KIRKLEES METROPOLITAN COUNCIL INVESTMENT & REGENERATION SERVICE

DELEGATED DECISION TO DETERMINE APPLICATIONS FOR CONSENT, AGREEMENT OR APPROVAL REQUIRED BY CONDITION

Reference No:	2025/44/92725/W
Site Address:	adj 67, Chapel Gate, Scholes, Holmfirth, HD9 1SX
Description:	Discharge of details reserved by conditions 7 (CMP), 8 (CEMP), 9 (road condition survey), 14 (invasive non-native species protocol), 15 (footway spec), 17 (road drainage structures), 18 (surface water spec), 19 (exceedance event), 20 (temp drainage) on previous permission 2022/92406 for erection of 10 affordable dwellings with access from Chapelgate and associated works including resident play zone
Recommending Officer:	Ellie Thornhill

DECISION – Discharge of Condition – Split Decision

SCALE	PAPER	STAGE	STATUS
1:200	A1	CONSTRUCTION	
DRAWING NO.			REV.
22055-DCE-XX-XX-D-C-100			C02

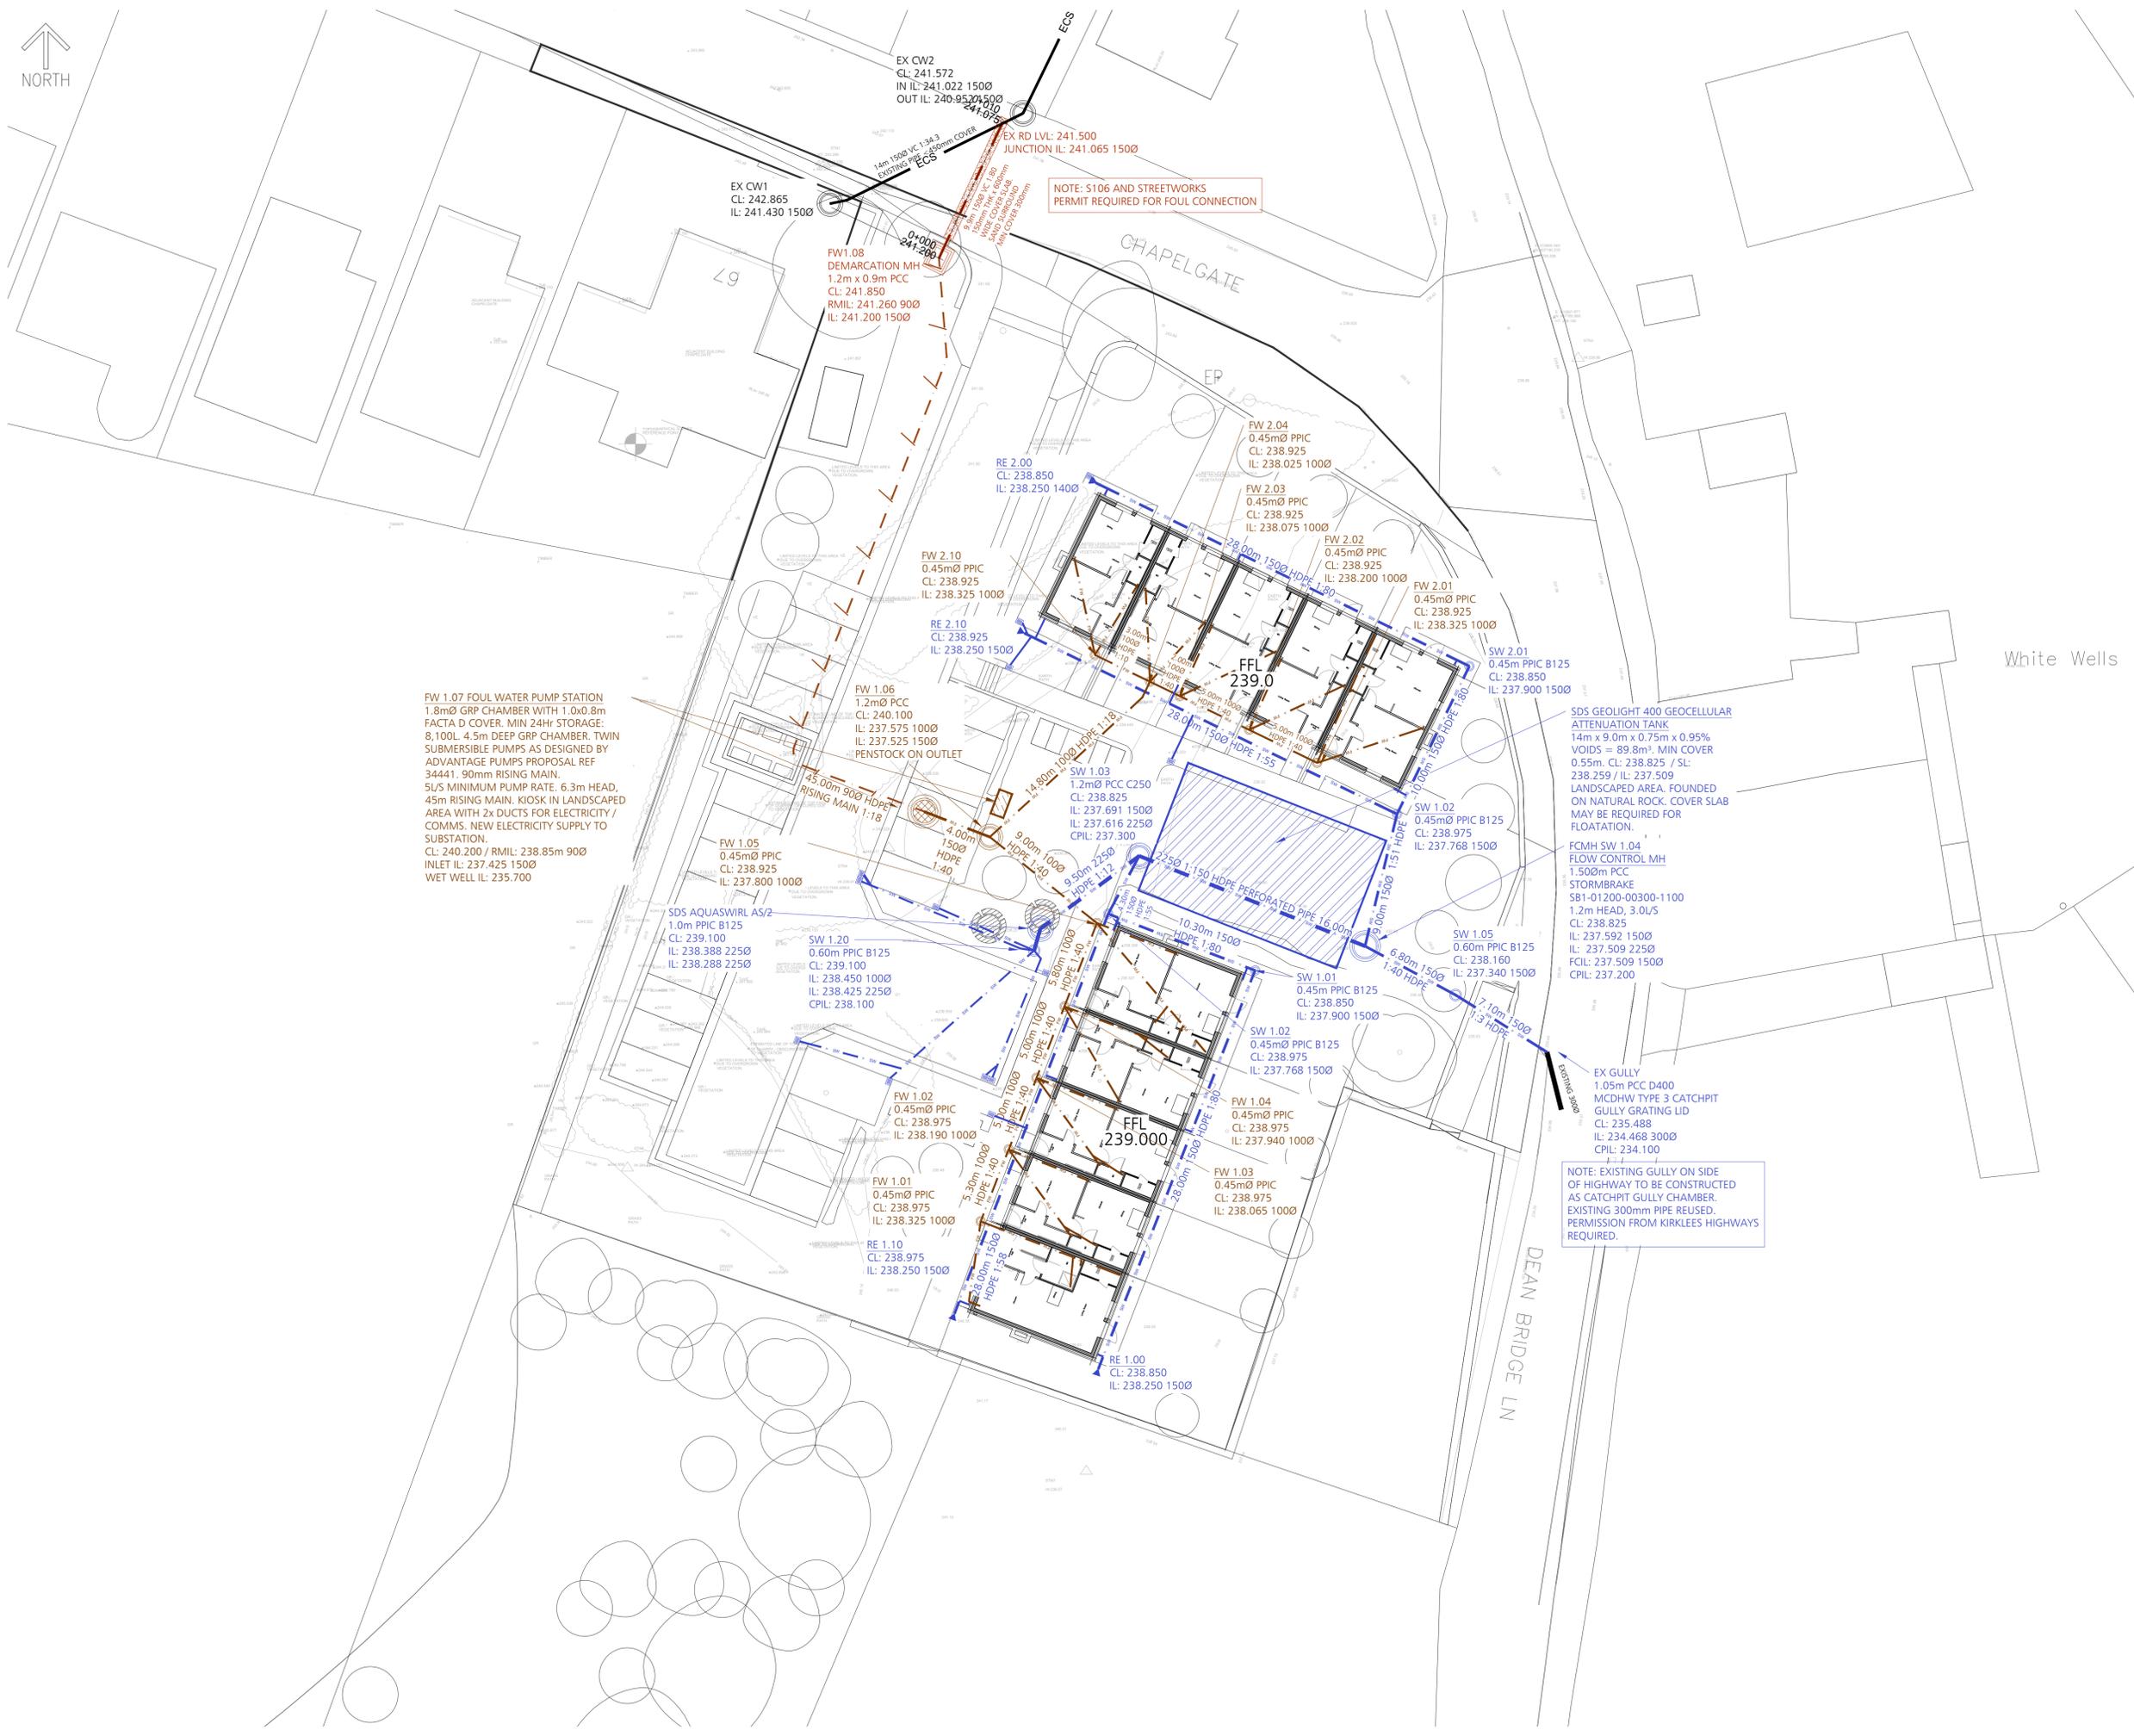
The LLFA consultation response dated 25/08/2022 requested that confirmation of the suitability of the highway drain into which the surface water drainage outfall will be connected. This information has not been supplied. The Flow Control Detail drawing appears to indicate that the flow control device is of the orifice plate type rated at 29.0l/s, whereas the Hydraulic Calculations show the flow control device as a vortex type rated at 3.0l/s. Note that the LLFA will not accept an orifice plate type of flow control and the drawing should be amended to concur with the calculations. No details regarding access into the attenuation tank or the maintenance strategy for the surface water system (including the tank, flow control, gullies etc.) have been provided. MH SW1.03 should be of the silt trap type to minimise the risk of siltation within the attenuation tank and please confirm the cover levels of all gullies are above the maximum water level during the design rainfall event. The LLFA will require further information/amendments and therefore Condition 18 cannot be discharged until these issues are addressed.

The CCTV Report appears to indicate connectivity between the proposed drainage connection and the watercourse via an existing 300mm dia vitrified clay highway drain – the LLFA confirm that this is accepted. The LLFA also accepts the proposed 3.0l/s allowable discharge rate for the surface water run-off from the development together with the results of the submitted hydraulic calculations (Ref: 22055-C-D01 dated April 2022). Therefore, Condition 18 can be discharged.

Figure 1: Invasive Plant location plan (*Buddleia davidii* not mapped)

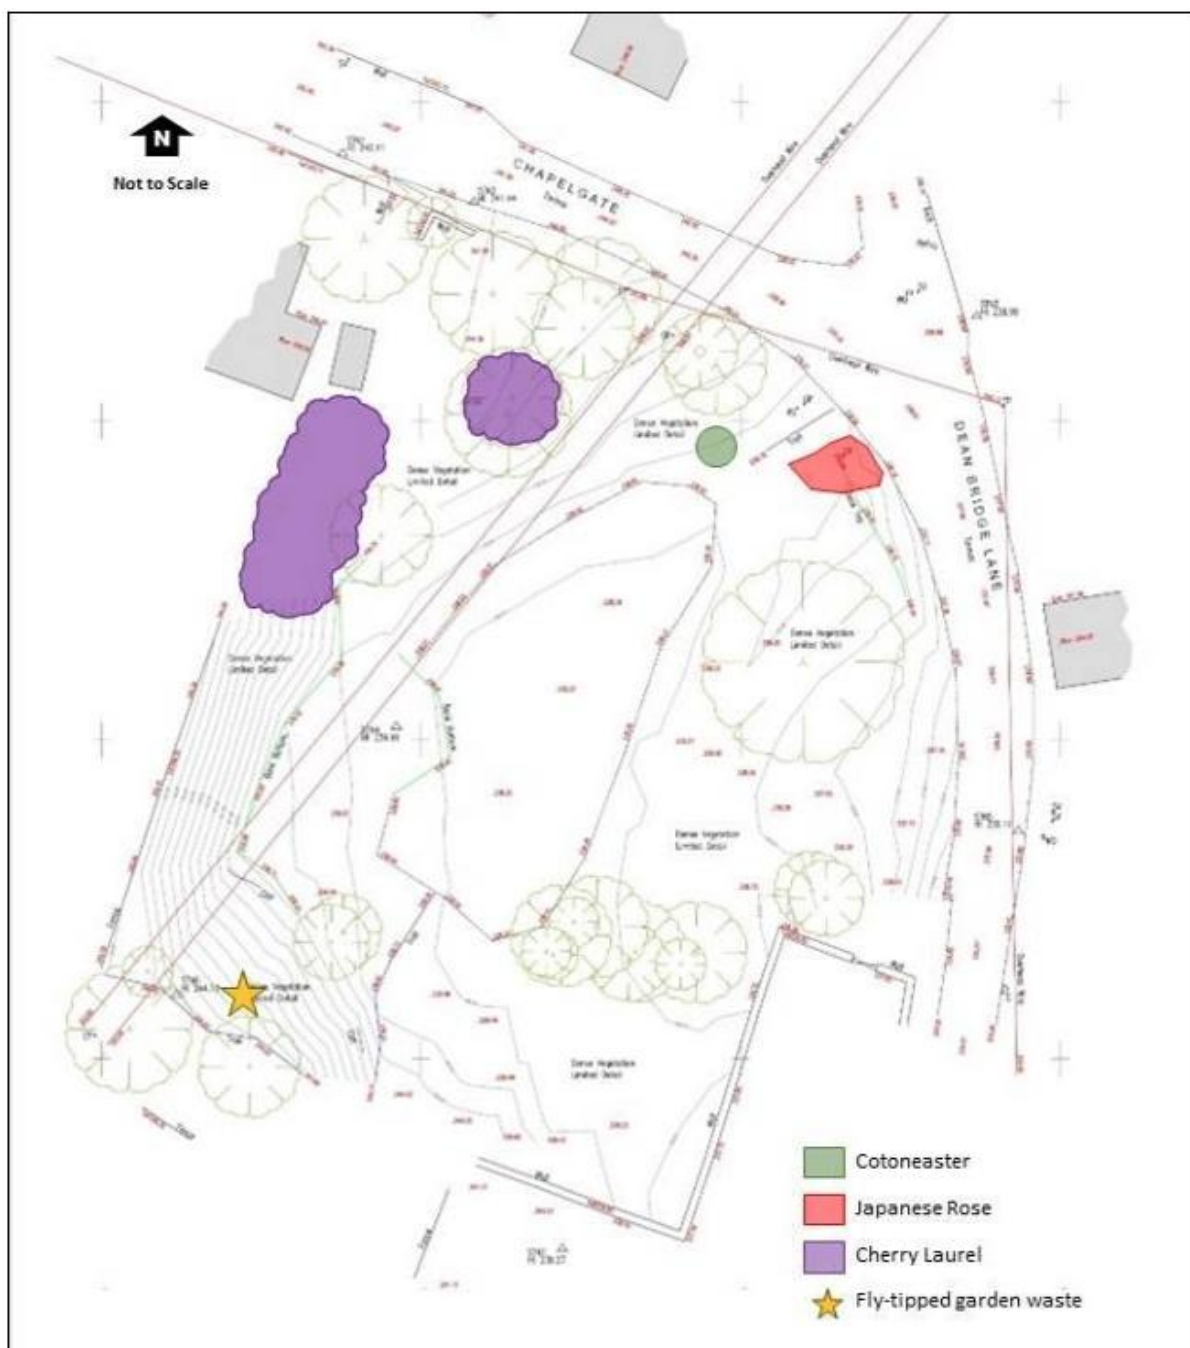
However, the Invasive Plant Management Plan submitted for this application does not include any information in relation to the species “buddleia Buddleia davidii”, as requested by condition 14.

Therefore, in the absence of this information a full assessment of condition 14 cannot be undertaken at this time and therefore, the Invasive Plant Management Plan should be updated/revised to include this specie. Should “buddleia Buddleia davidii” no longer be present at the site, an explanation as to why, would be required.
